Response to Planning Application

Application ref: A/157/21/DOC

Description: Approval of details reserved by condition imposed under A/125/13/ relating to condition 17-landscape scheme

Location: Chandlers BMW Worthing Manor Retail Park Rustington BN163FH

scheme: Mill Lane Site
client: Store Property
drawing: Landscape Proposals
date: Sep '13
scale: 1:200@A1
drawing no: STORE18832 13A
drawn: DKM checked: AW

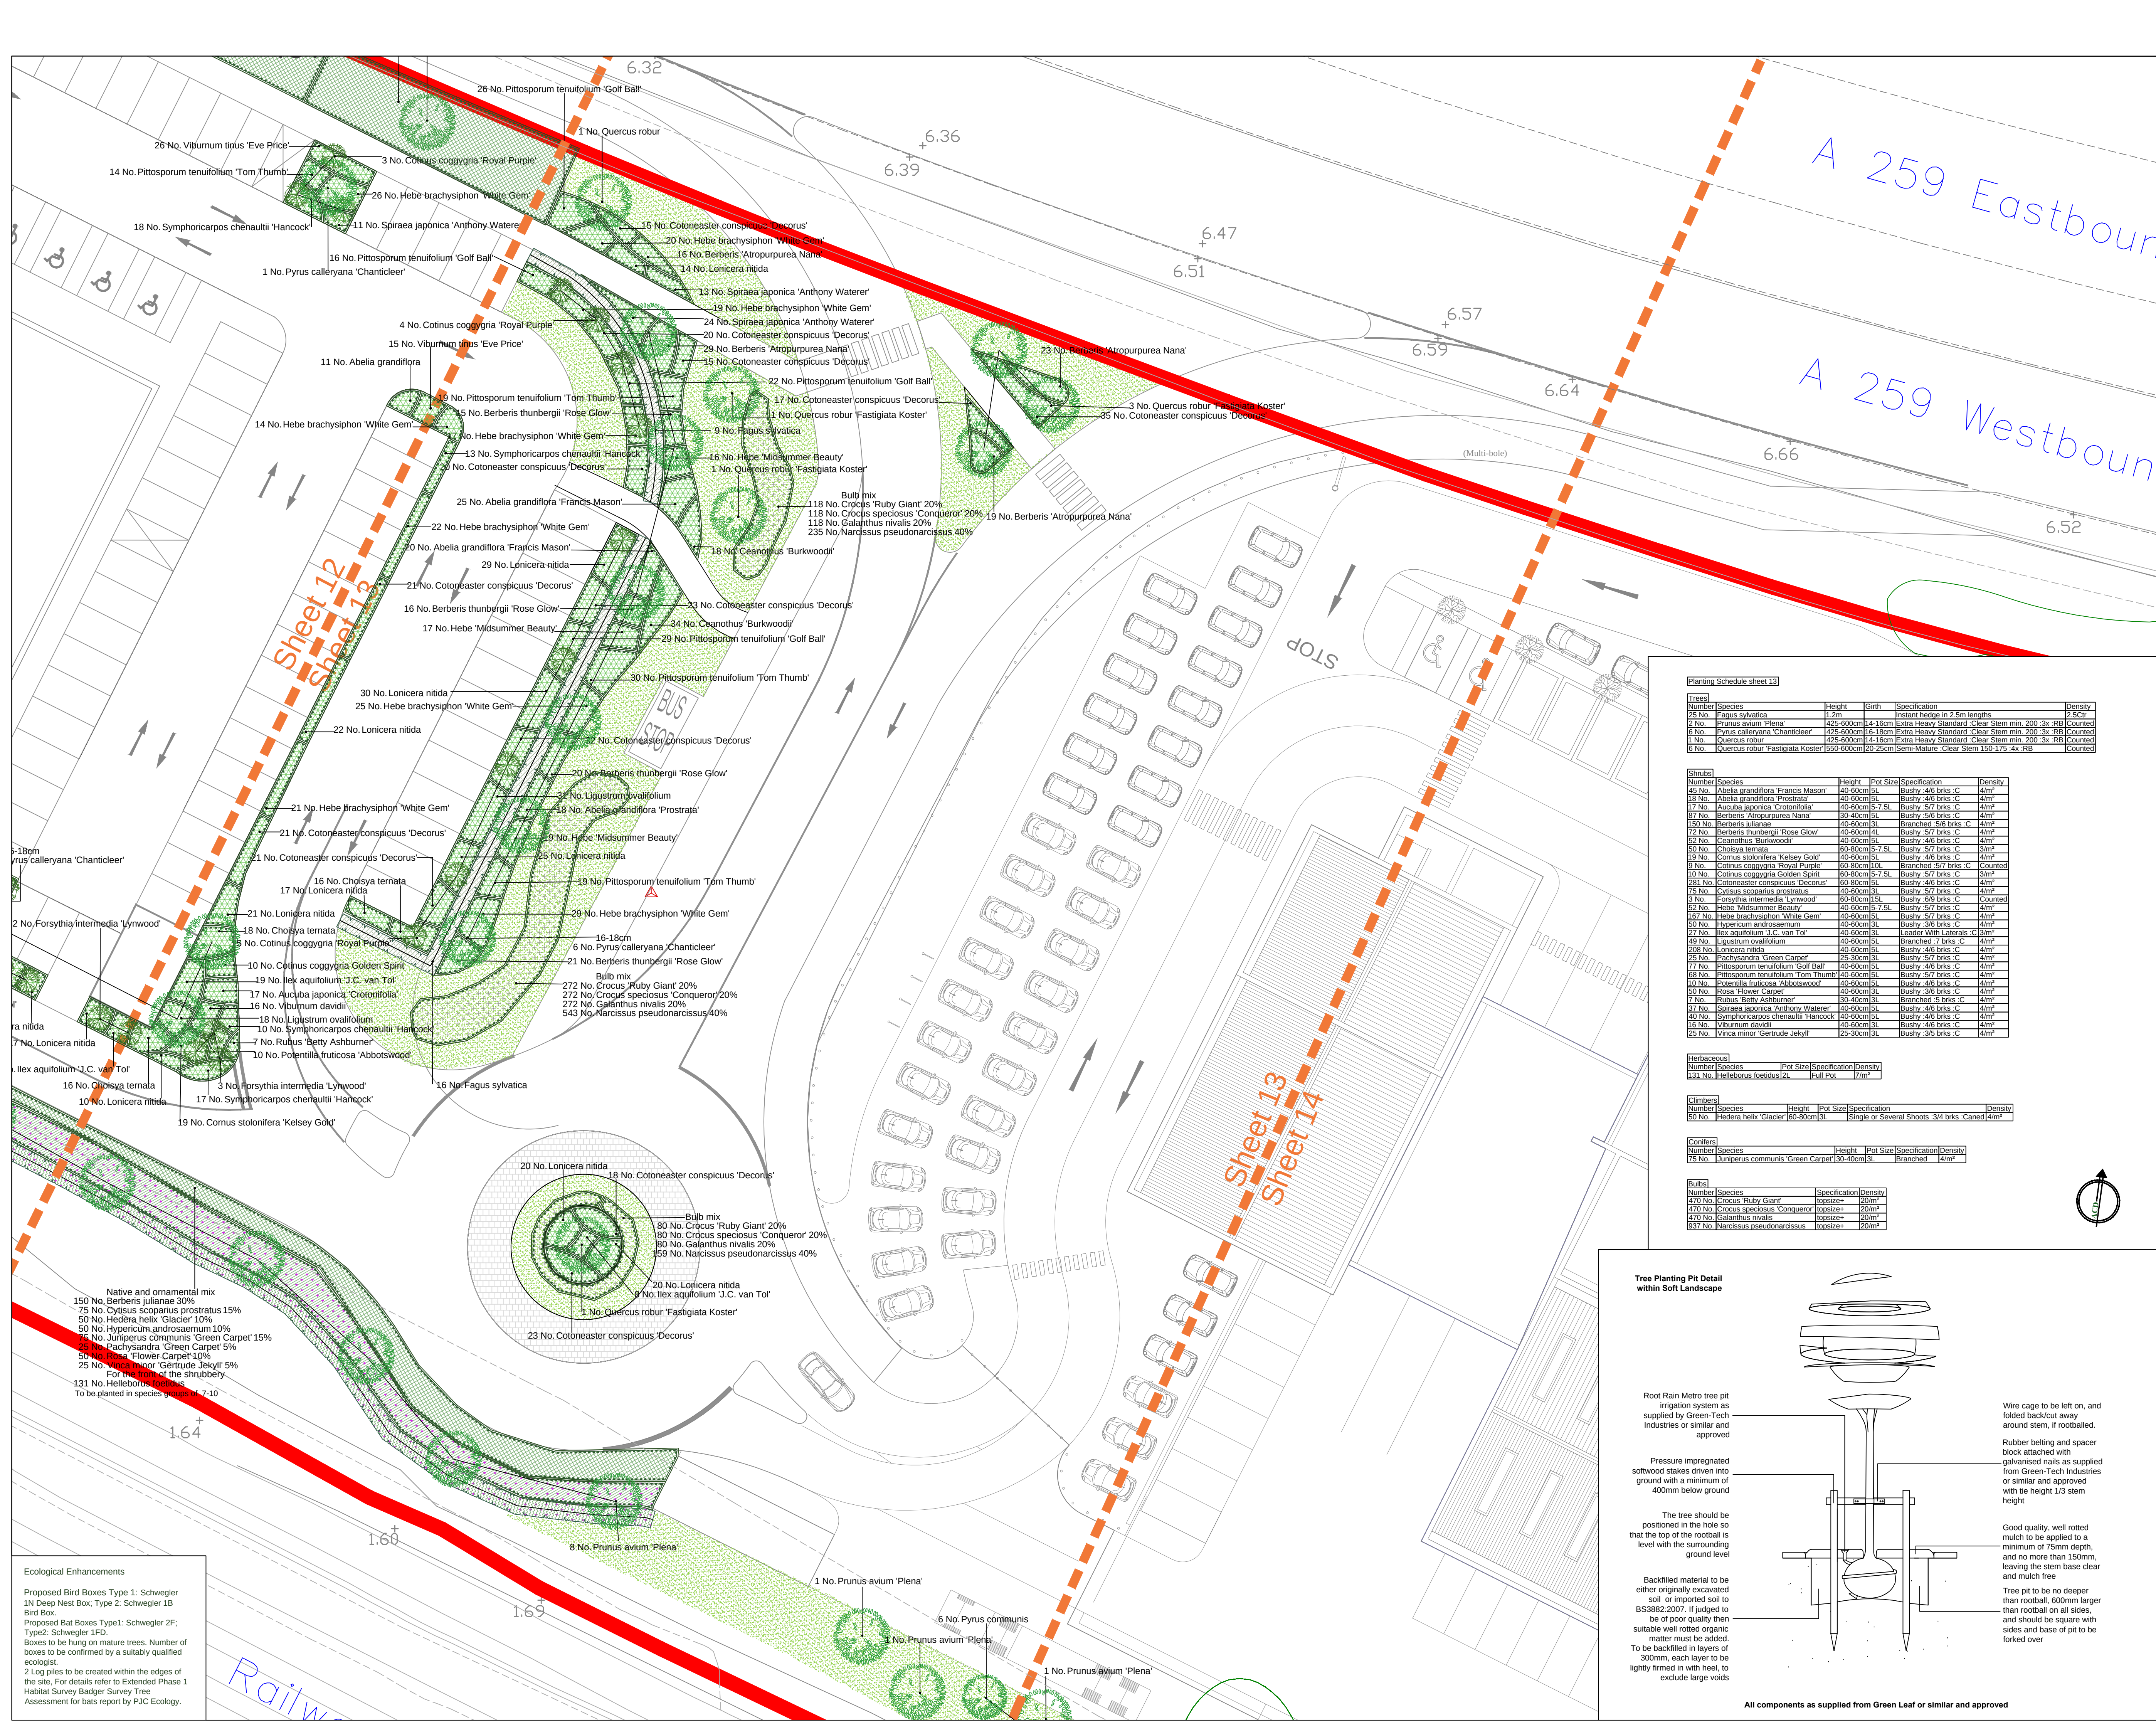
I draw your attention to the original planning application A/125/13 when approval was given and to the detail approved under submitted plans Superseded 05/02/2014 Site Block Plan L(00) 103 Rev G and Store 18832 14D Substitution 05/02/2014 which provided Landscape detail which included a substantial landscape scheme with planting and trees shown within the car park areas indicating 41no trees sizes 14-16 and 16-18 cm girth to the northern aspect road frontage of the site with a substantial planting proposal to the rear of the building which indicated 24no trees in this area.

The scheme submitted under this application in dwgs Planting Plan 1 of 2 PL36L01 REV PR0 and Planting Plan 2 of 2 PL36L02 REV PR0 and in contradiction to the detail shown under Landscape Proposals Store 18832 14A dwg has detailed a very poor and inadequate Landscape scheme for this site and location. A scheme needs to be proposed which is representative of the detail which was provided within the approved application and which enhances and softens the site in keeping with the adjacent scheme to the west of this site.

Planting Plan 1 of 2

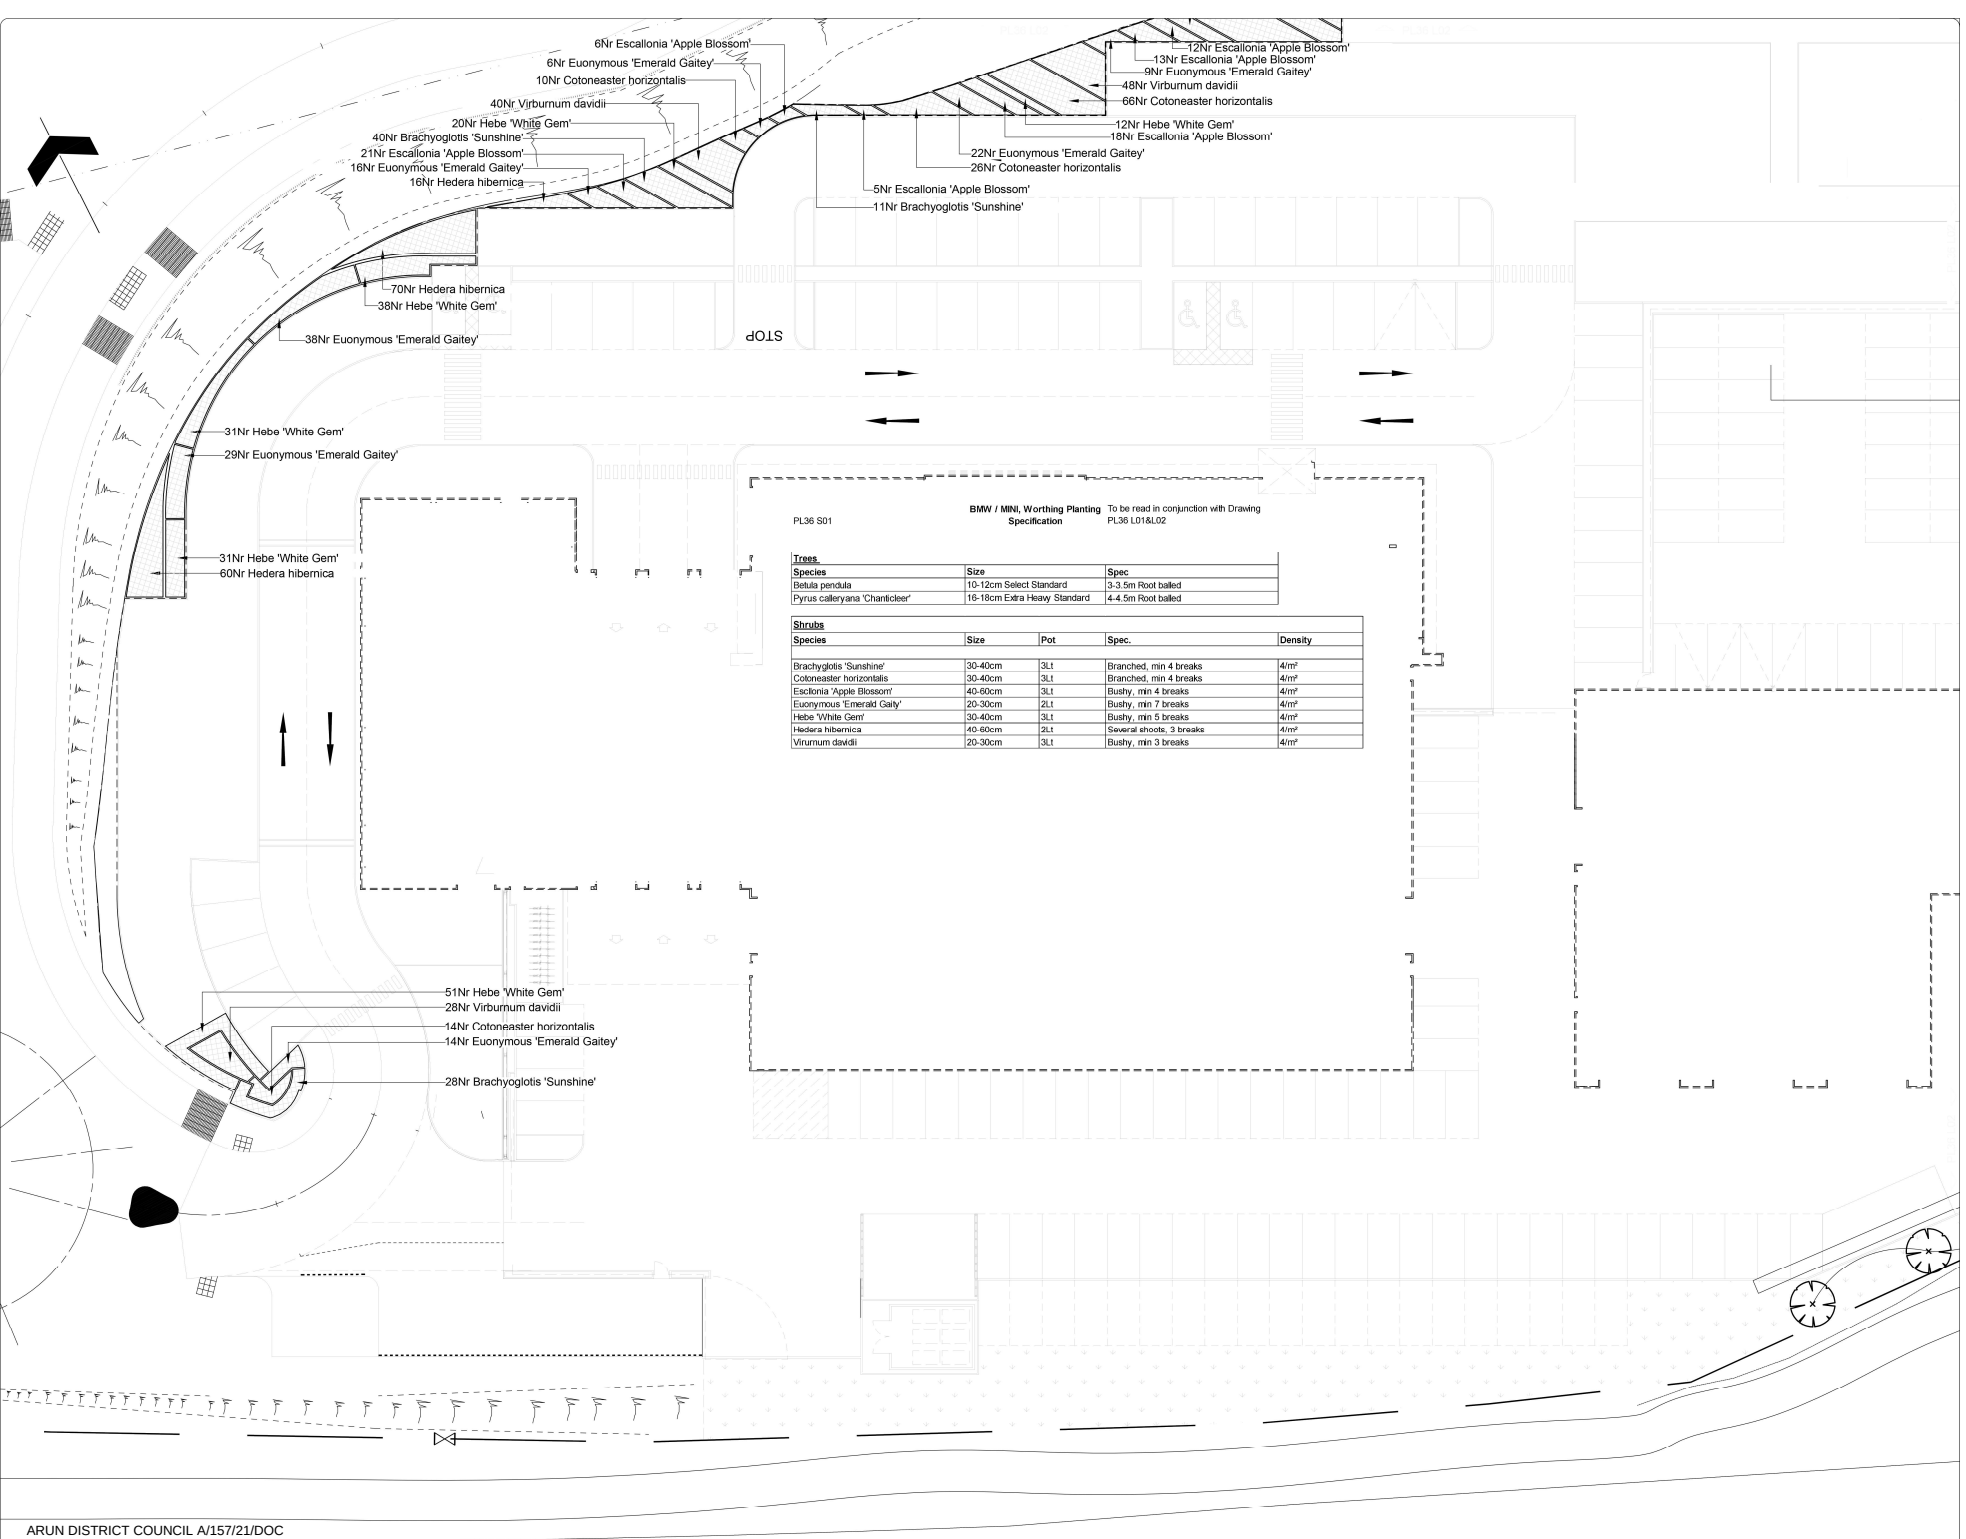
The landscape proposals now submitted are contradictory to those previously submitted and now show the bare minimum of a ground cover planting scheme with little variation or biodiversity habitat potential. The scheme submitted does not propose any trees to the frontage and only 6no Standard Birch 8-10cm girth to the rear.

The plans submitted do not show adequate detail within the submitted plans. The scheme submitted has failed to follow that which was previously proposed and failed to address the mitigation for trees removed on this site.

The proposals need to take into account that the tree sizes need to be specified at a size which represents the loss of growth potential since the building was completed ie at an EHS Extra heavy size specification. The proposed landscaping needs to be given suitable ground conditions and planting medium to allow them to establish and thrive and adequate maintenance provision to achieve this.
